Objection to ABP Case Number 324290 by Scott Coombs

This submission constitutes a formal objection to the proposed Lissinagroagh Wind Farm on the grounds that the Environmental Impact Assessment Report (EIAR), specifically Chapter 13 (Landscape and Visual), is materially deficient, methodologically flawed, and fails to comply with statutory requirements under the Planning and Development Acts and the EIA Directive (2014/52/EU).

Figure 13-13: Map of Viewpoint Locations

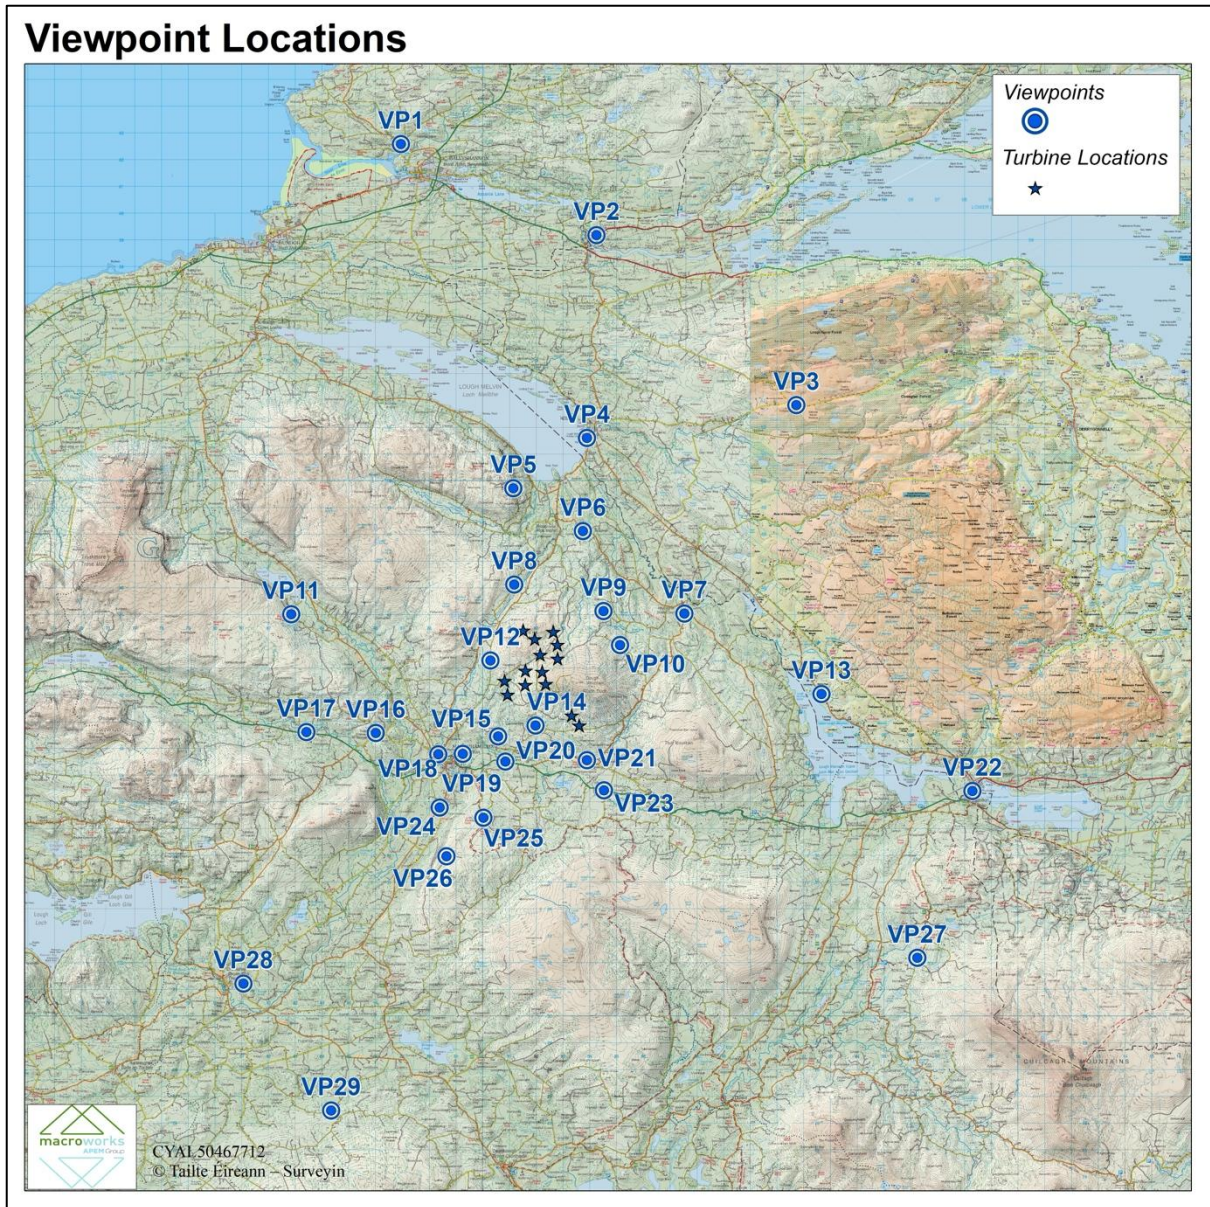
- **Absence of Representative Viewpoints:**
No primary viewpoints are located within the core of the Boleybrack uplands. The only viewpoints (VP25 Tullysheherny and VP26 O'Donnell's Rock) are peripheral and do not represent the most sensitive receptors.
- **Systematic Underrepresentation of Impact:**
By excluding central upland viewpoints—including the L2206 corridor (Glenboy–Gortnalibbert–Meenymore)—the EIAR avoids assessing the most severe and direct visual effects.
- **Contradiction of Capacity Study Guidance:**
Appendix IX (Part B), Section 3.4.3 of the Landscape Capacity Study explicitly states:
“careful design would be needed to limit the visual influence of any wind turbines... on the scenic Boleybrack mountain skyline.”

- The route is not assessed as a primary viewpoint
- It is absent from formal scenic route analysis
- It is not classified as a high-sensitivity receptor

The EIAR’s failure to include this receptor constitutes a selection bias in viewpoint methodology, leading to systematic underestimation of impact.

The EIAR's viewpoint selection is flawed in that it:

- The result is a non-representative visual assessment, rendering conclusions unreliable.
